From: Laura Gibbons <laura.gibbons@arun.gov.uk>

Subject: RE: Y/9818/RES and Y/97/18/DOC

From: Laura Gibbons <Laura.Gibbons@arun.gov.uk>
Sent: 22 July 2019 11:07
To: Luke Hart [REDACTED]
[REDACTED]

Job Title		
LAND SOUTH OF BURNDELL ROAD, YAPTON		
Drawing Title		
PRIVATE DRAINAGE CONSTRUCTION DETAILS SHEET 1 OF 2		
Client		
BOVIS HOMES		
Scale	Date	Designed
NTS @ A1	APR 19	SG
Drawn	Checked	Approved
TSB	SG	LH
Job No	Drawing No	Rev
18-070	18-070/110	C

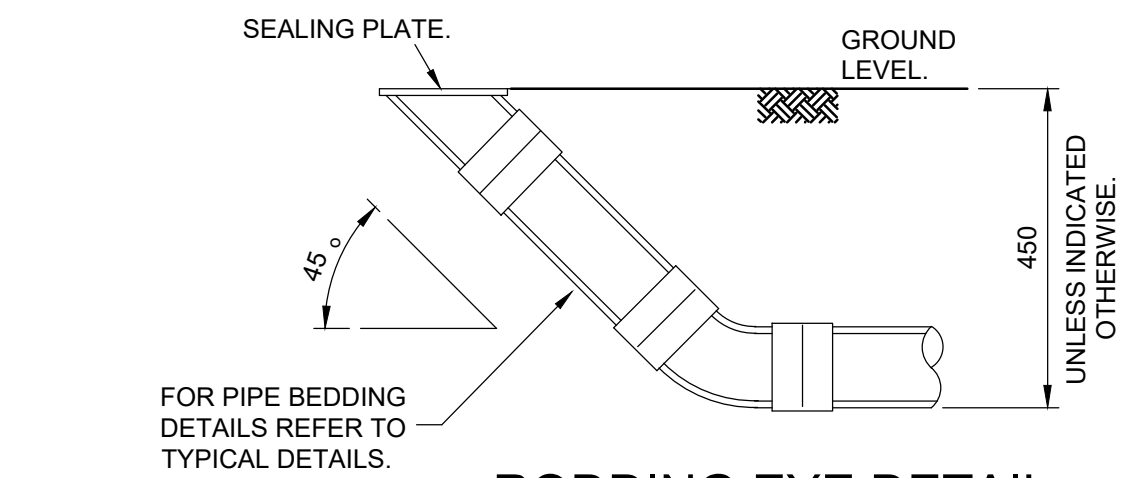
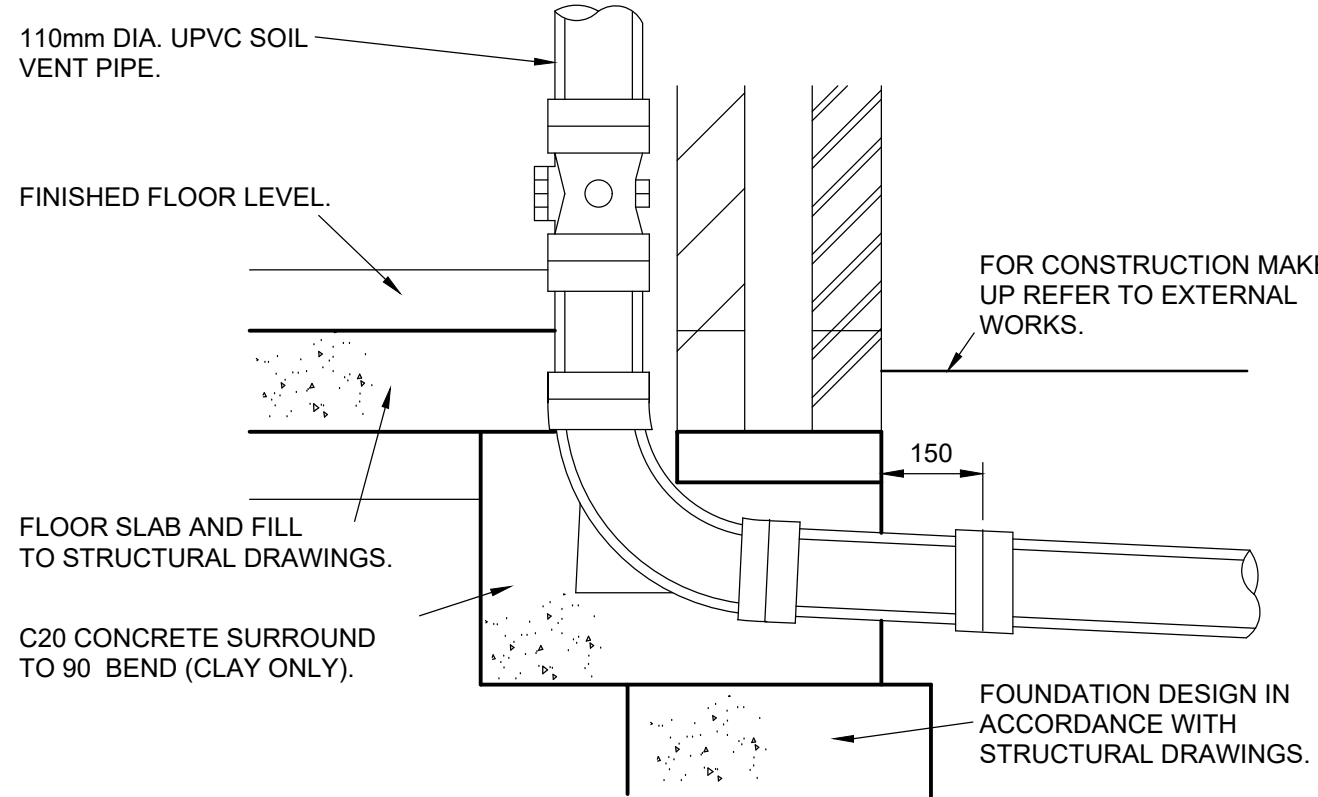
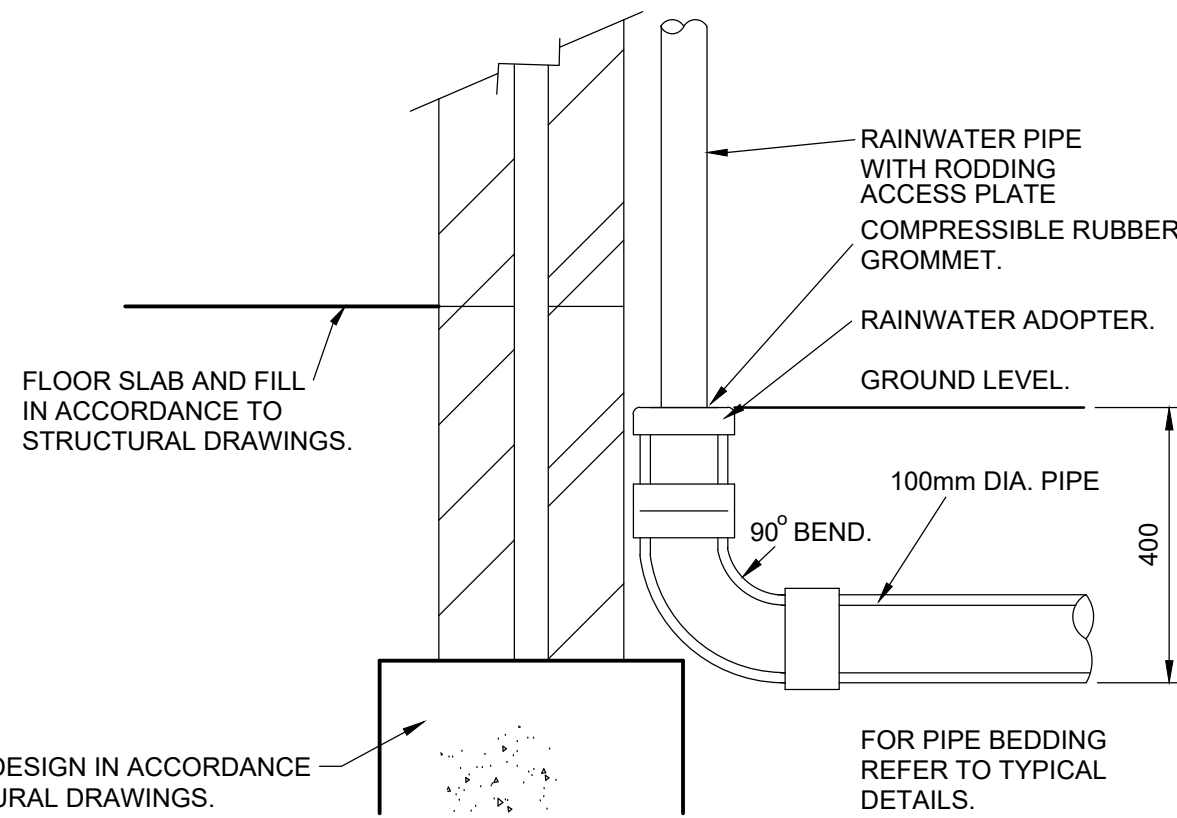
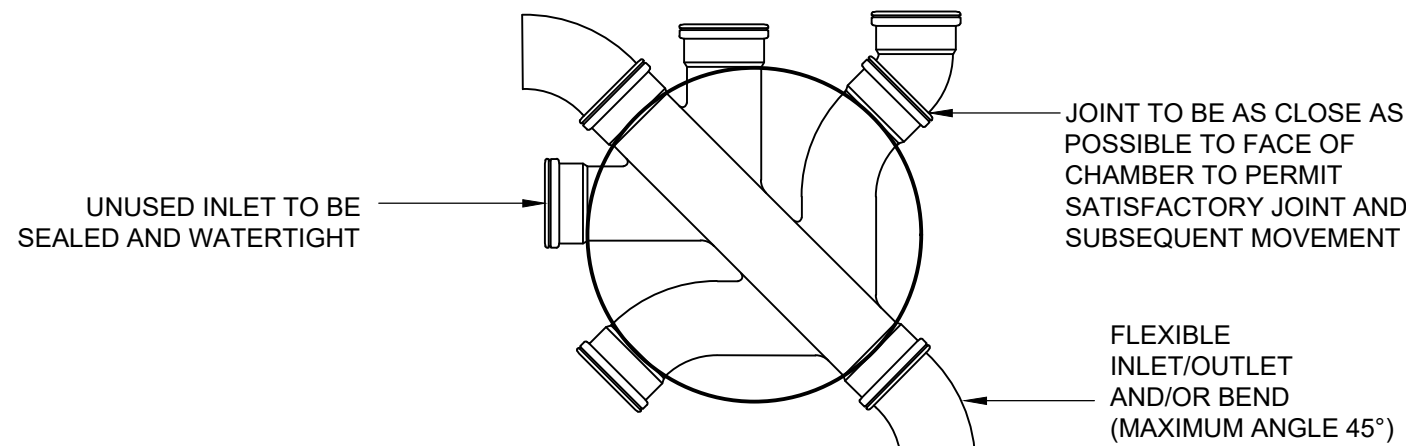
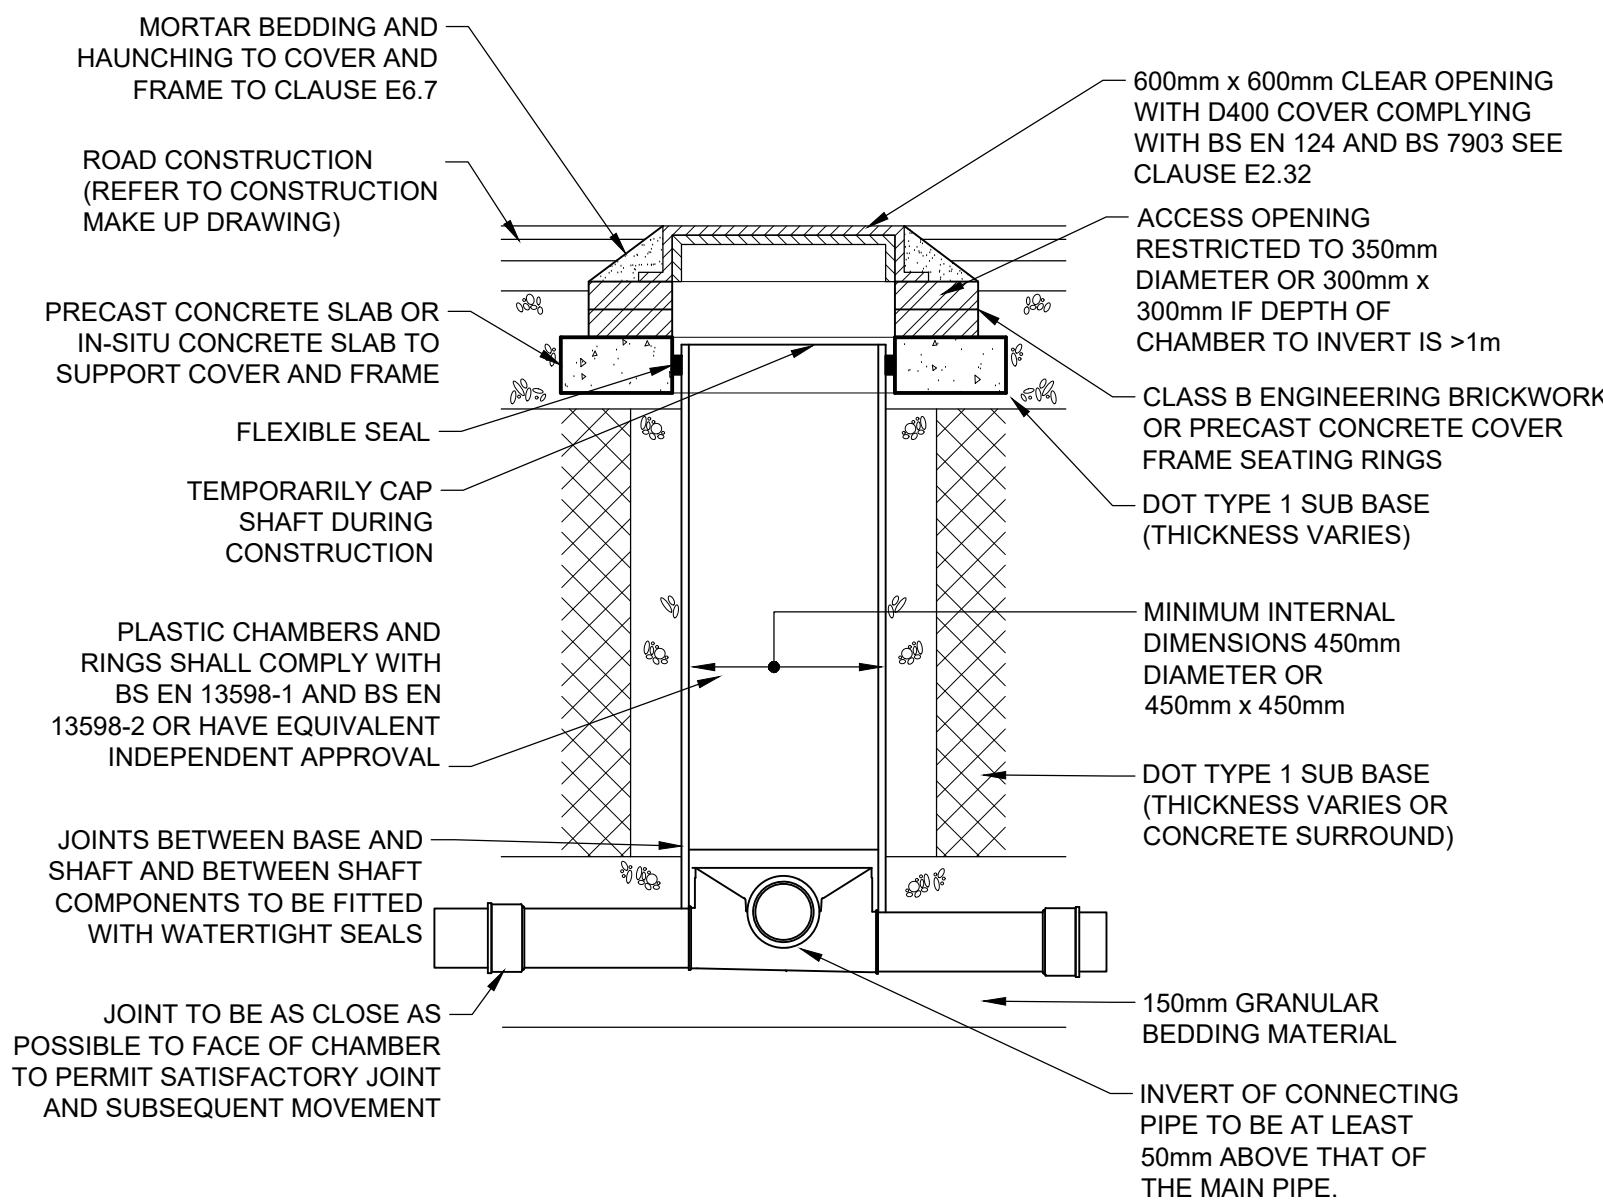
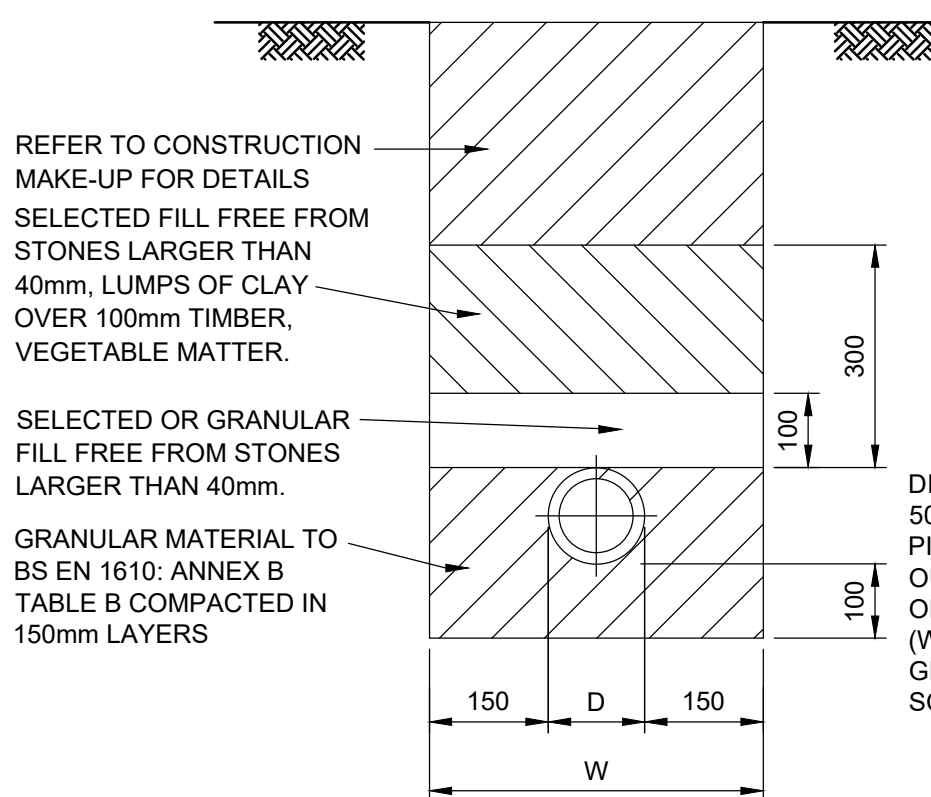
8. In some locations there are significant drops between orifice invert level and the invert level of the main surface water pipe. Please provide a detail that accurately represents this. Detail has been added to drawing 18-070/111.

Drawing Title
PRIVATE HIGHWAYS CONSTRUCTION DETAILS

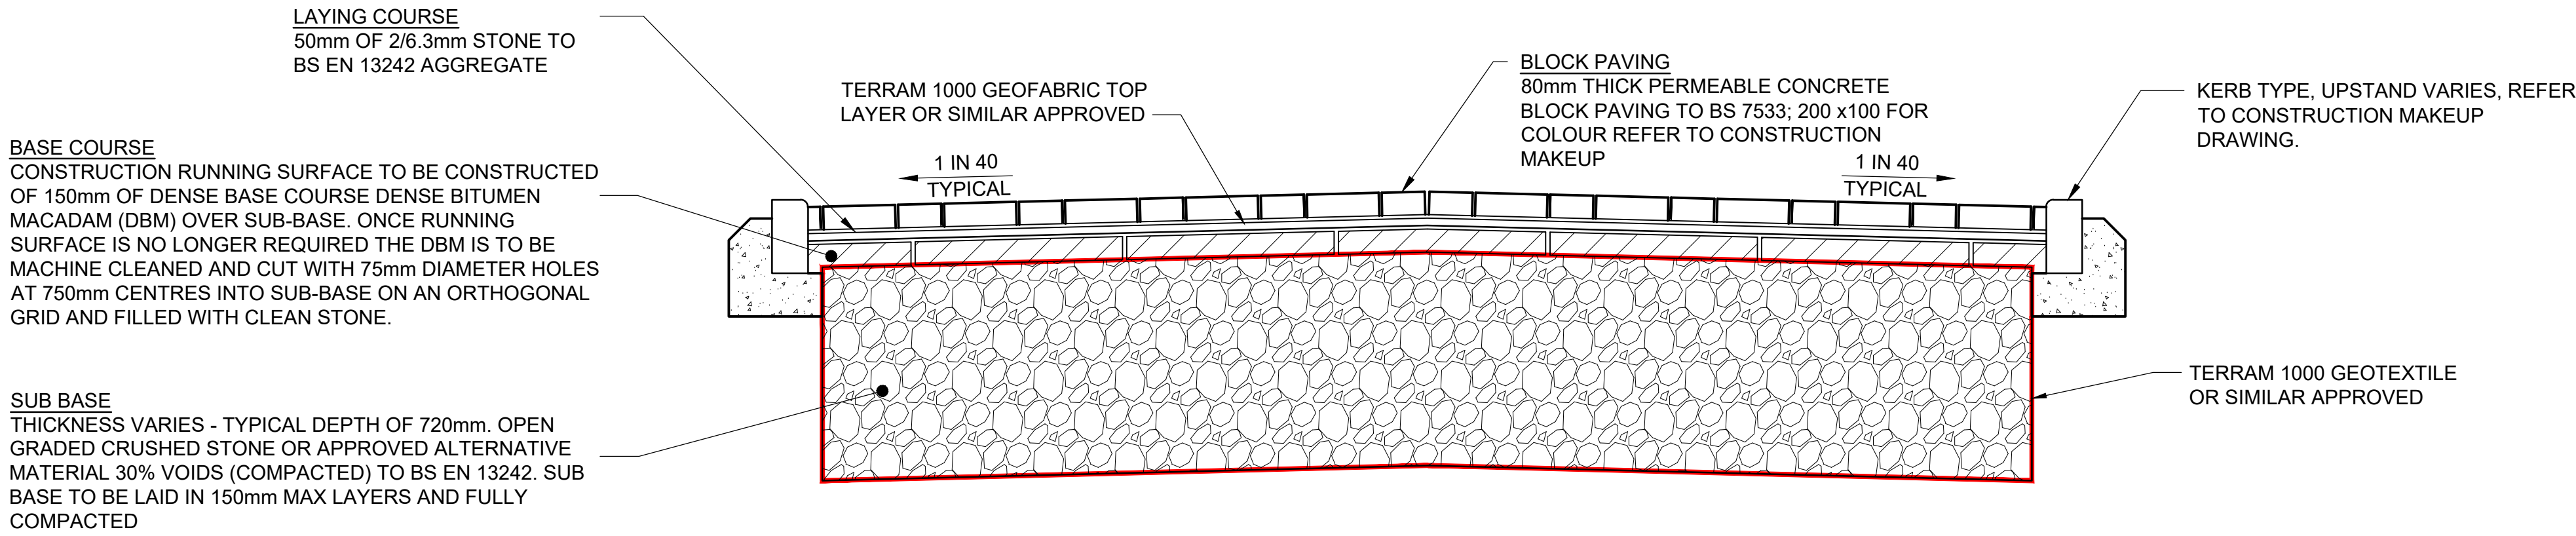
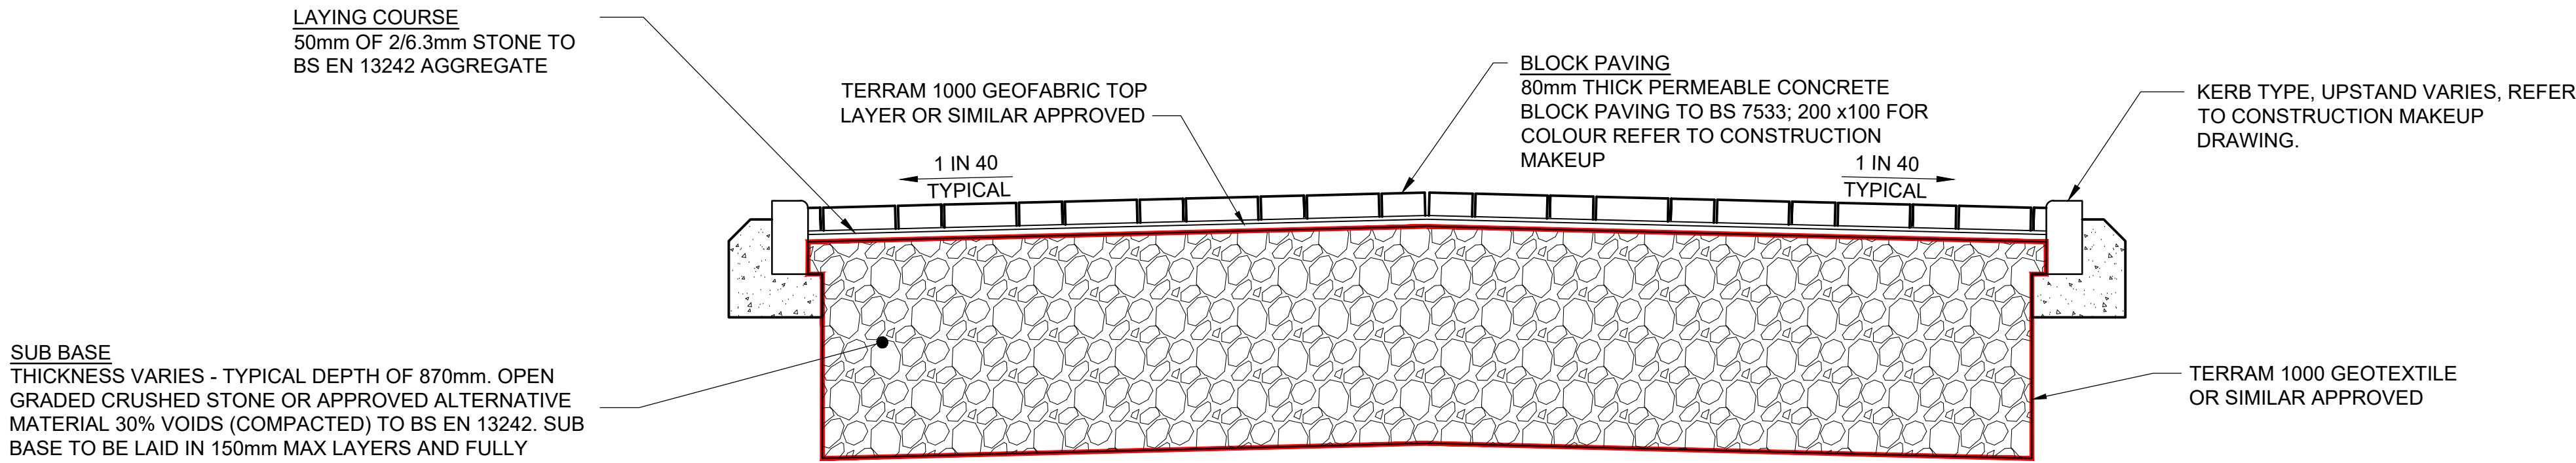
5. Please update the construction detail drawings to show permeable geotextile wrap fully around the sub-base. Detail has been updated. *Please update so geotextile is under tarmac, not over it. Detail amended and attached.*
